Our Case Number: ACP-323742-25

Re: Proposed development comprises the development of an extension to the existing Burial Ground at Drumcliff Burial Ground located at the Townland of Drumcliff, Ennis, Co. Clare
Drumcliff, Ennis, Co. Clare

Submission on s.177AE application JP03.323742 for proposed development comprises the development of an extension to the existing Burial Ground at Drumcliff Burial Ground located at the Townland of Drumcliff, Ennis, Co. Clare.

CLIENT: Clare County Council
TITLE: Watermain & Storm Water Sewer Layout

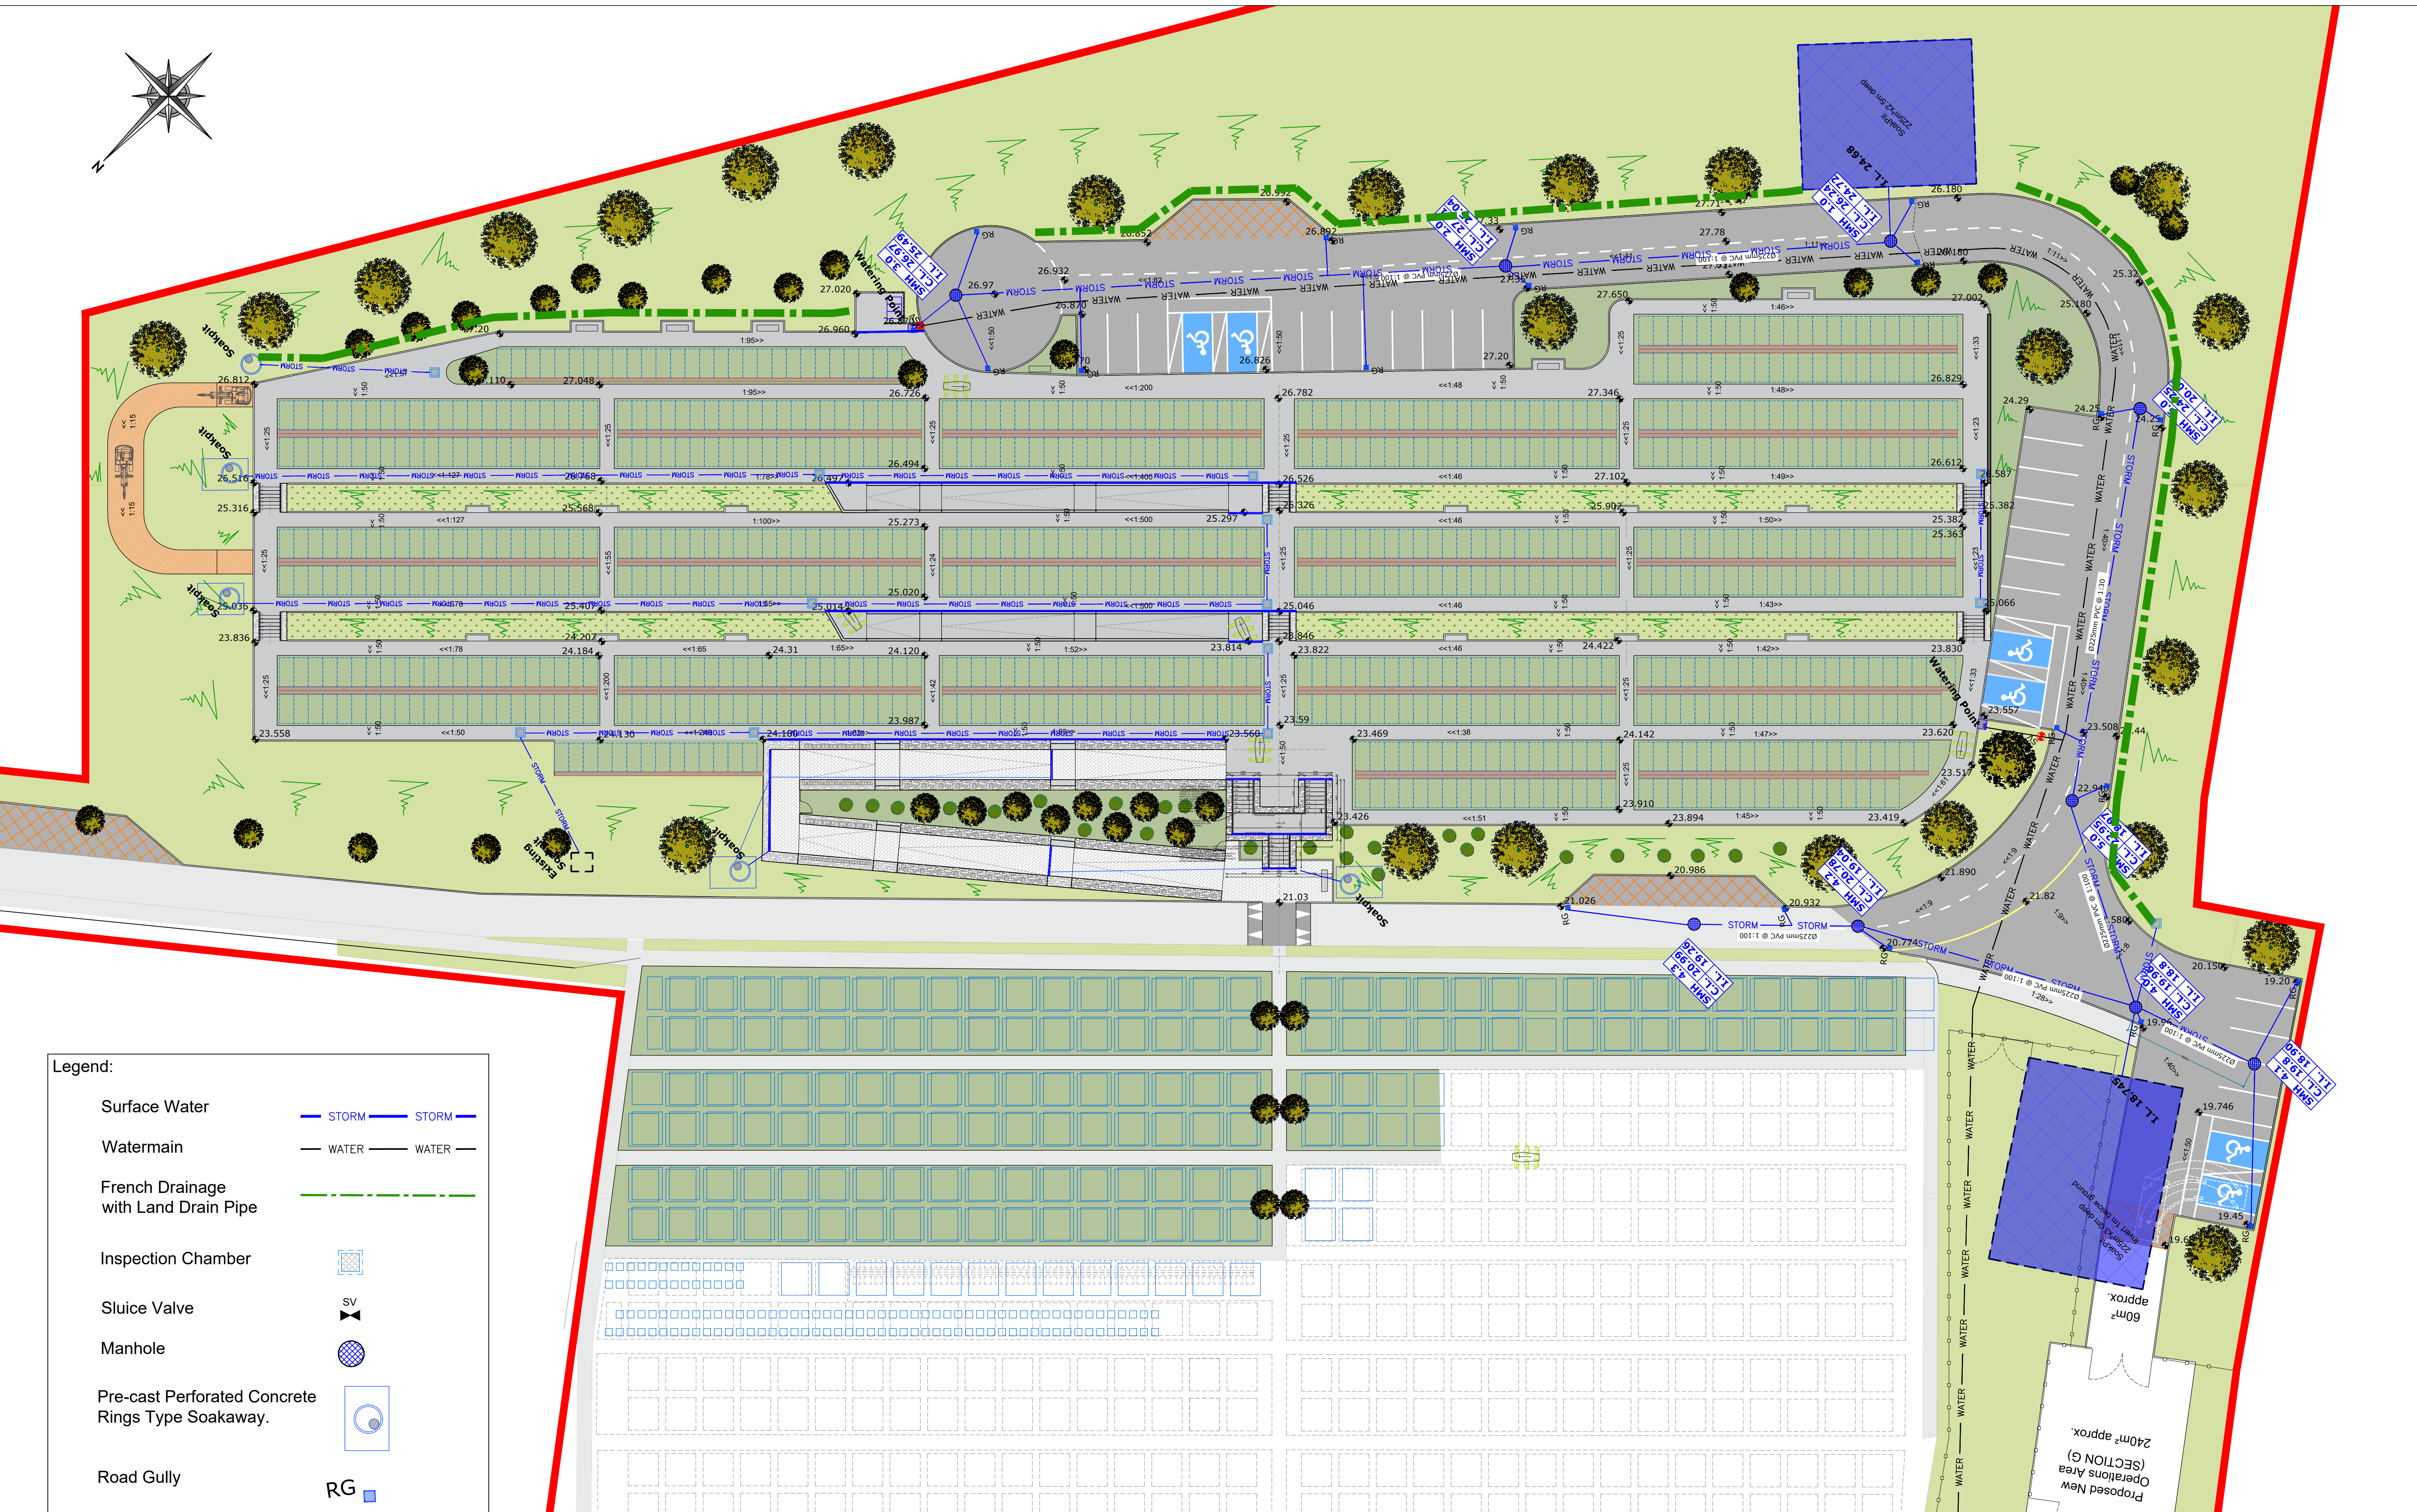
- *The drainage design incorporated into the proposed development will ensure that surface water will be collected, treated and retained within the site, with infiltration to ground via 5 no. proposed soakaways;*

7. There is no assessment of infiltration, potentially directly to the karst conduit, feeding the potable source at Drumcliff Spring.
- *The conceptual site model of the site is outlined in Section 4.1 and in summary is conceptualised as a sloping site, underlain by thick clay-rich subsoils (8.5-13.5m) which form a drumlin feature overlying the limestone bedrock which forms the primary groundwater aquifer within the region. Low/moderate permeability rates indicate*
